From: Thomas Callaway
Sent: 21 February 2017 16:30
To: Planning.Responses
Subject: RE: Planning Consultation on AL/9/17/DOC

APPLICATION **AL/9/17/DOC**
NO:

Site Address: The Gatehouse Lidsey Road Aldingbourne

Description of Works: Application for approval of matters reserved by condition imposed under AL/99/15/PL relating to condition no. 4 (Surface Water Drainage), 5 (Landscaping) & 9 (Foul Drainage)

project	Residential development The Gatehouse. Lidsey Road. Woodgate		
detail	site levels as proposed		
drawn	sgr	checked	
date	09-15	status	Const.
a1 scale	1:50	a3 scale	1:100
	8590	rev	B

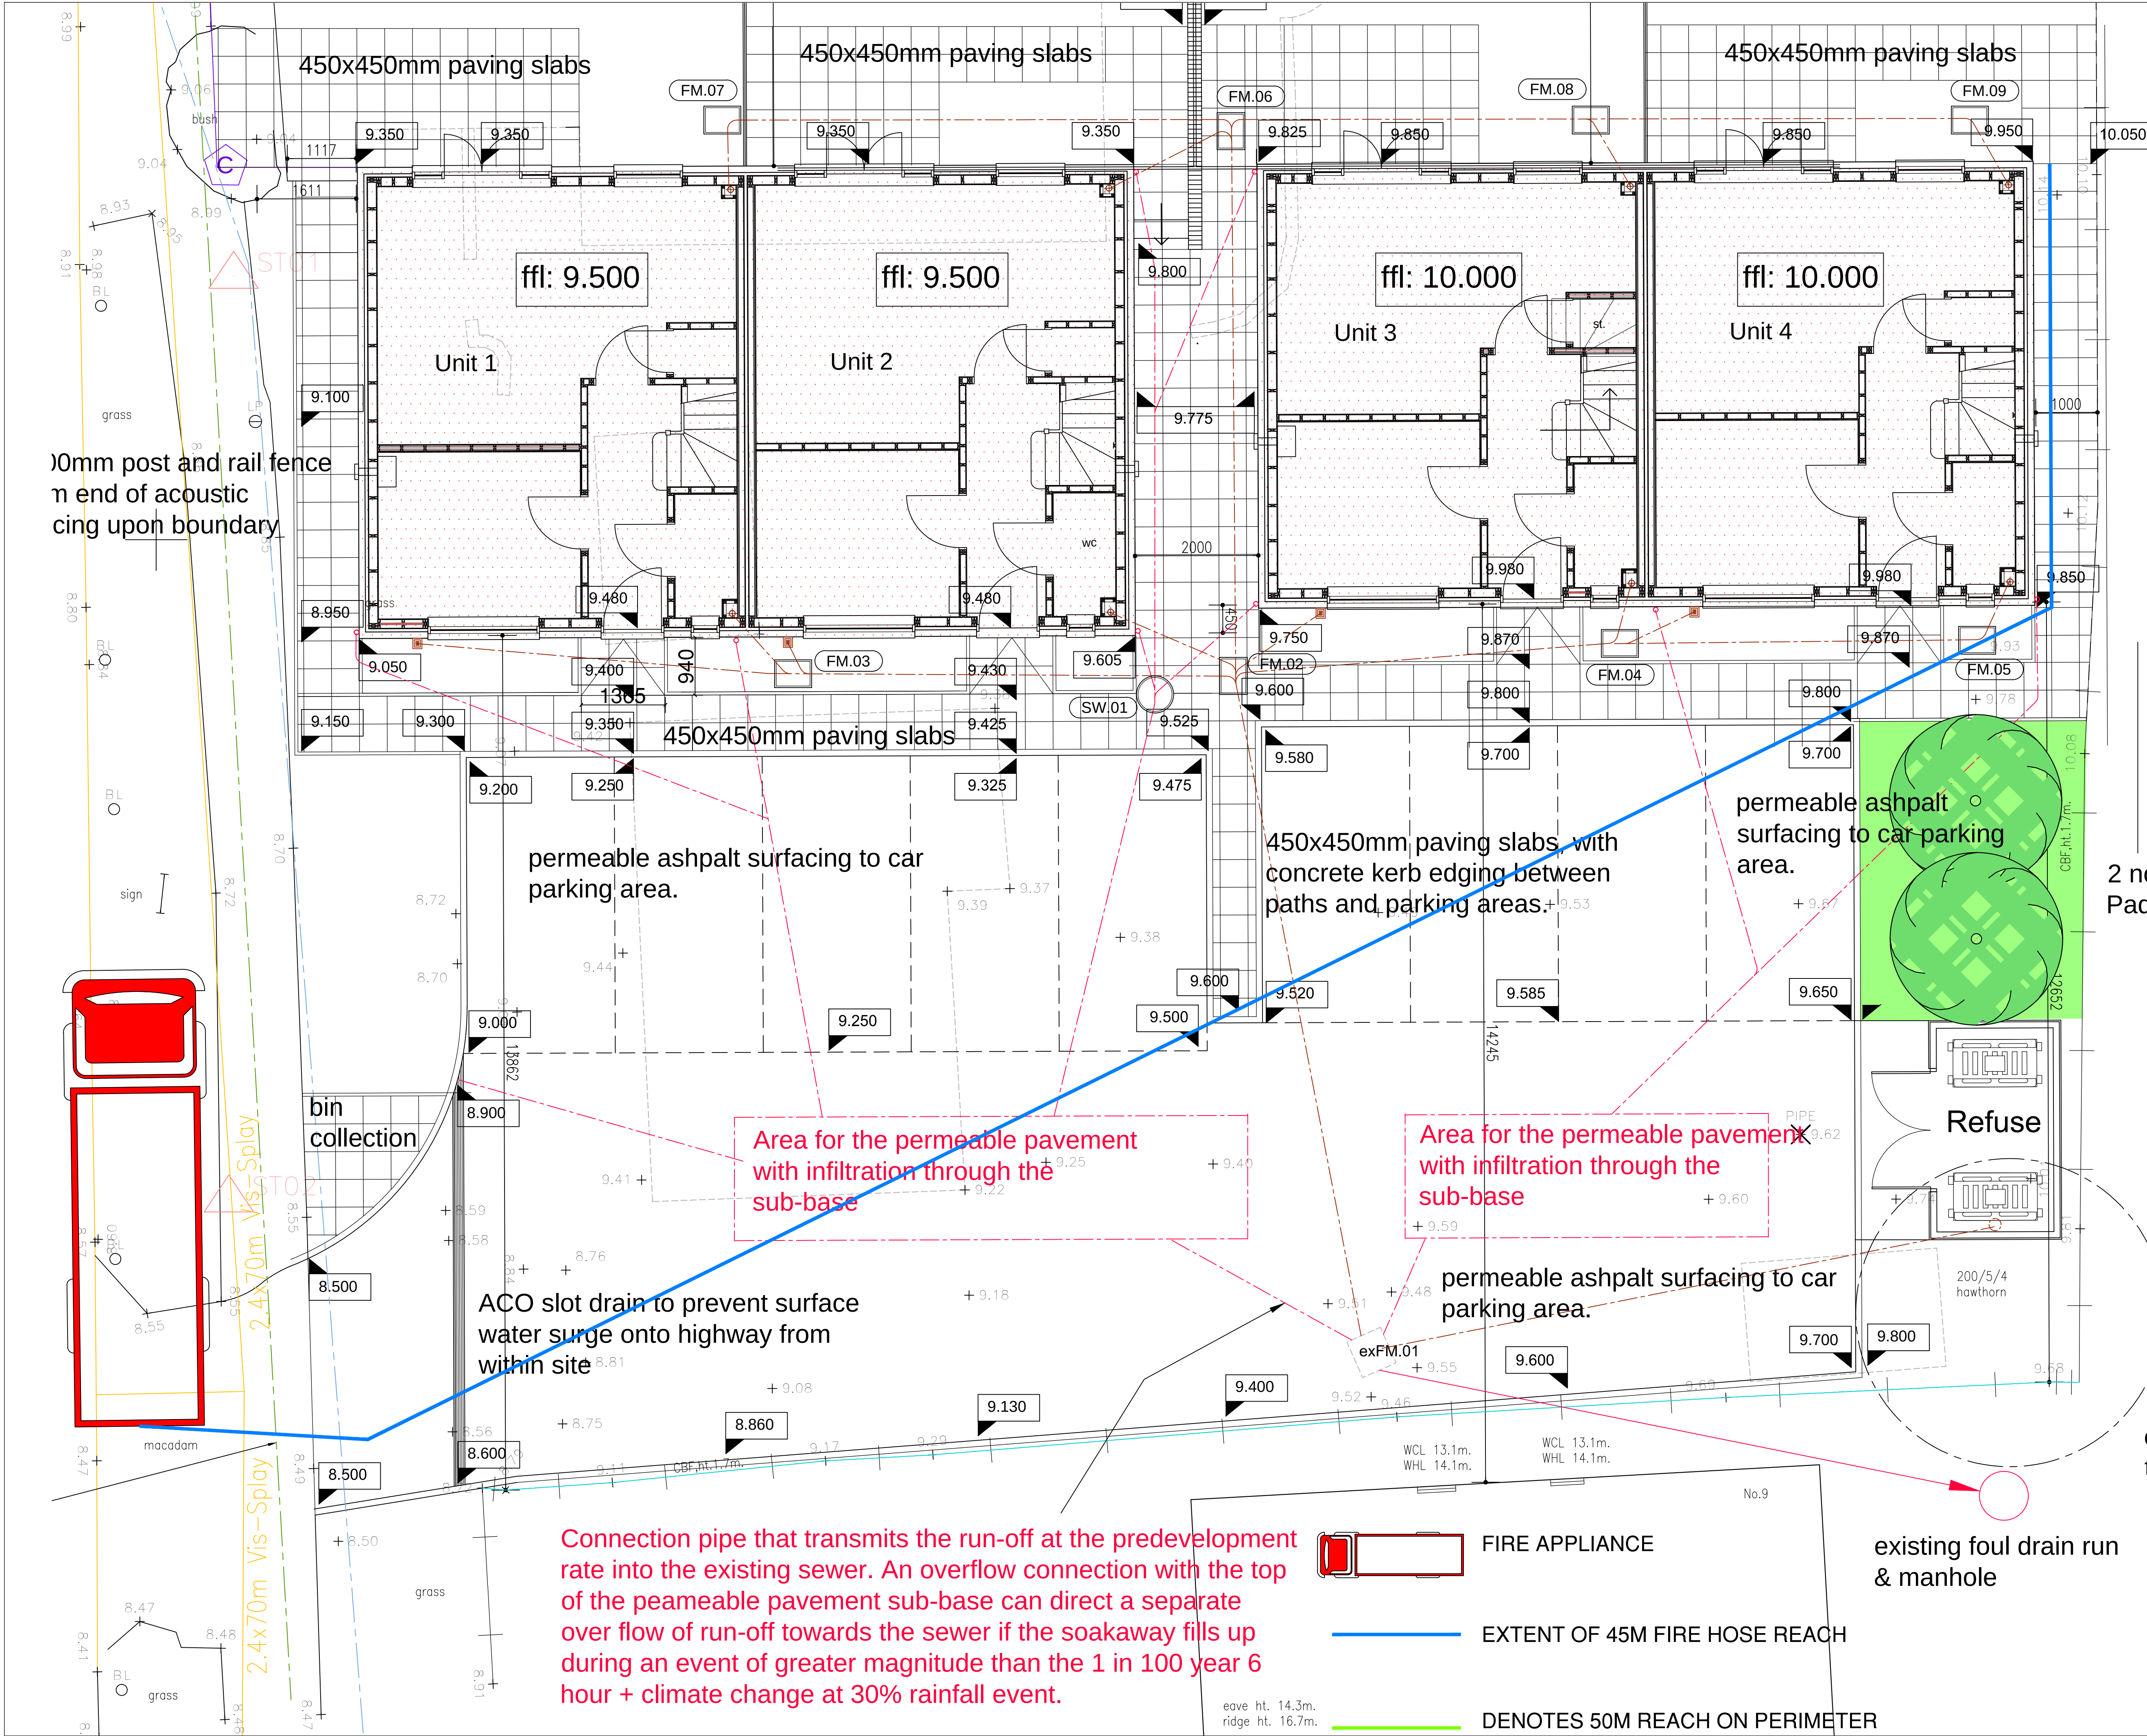
Proposal for permeable paving with geocellular crate sub-base of 30 sq m area and 0.52m depth sub-base/crates. For type B systems it is stated that maximum depth would be 0.42m for sub-base/crates. The storage volume for the 1 in 100 year storm event plus 30% climate change allowance would be provided by increasing the area to 42 sq m with 0.42m sub-base/crates at 95% voids. The half drain time would exceed 24 hours but not by a large amount.

The issue with having an overflow to the existing sewer is that we have no record of any public surface water sewer to discharge to and no further information on private sewers. If this sewer discharges to the foul network then we would not allow any surface water flows to be discharged to this system, even from an overflow. All existing surface water flows to a foul system should be removed. Please provide evidence that shows the existing sewer does not flow to a foul system, otherwise we will definitely require full infiltration with the increase in storage as proposed above.
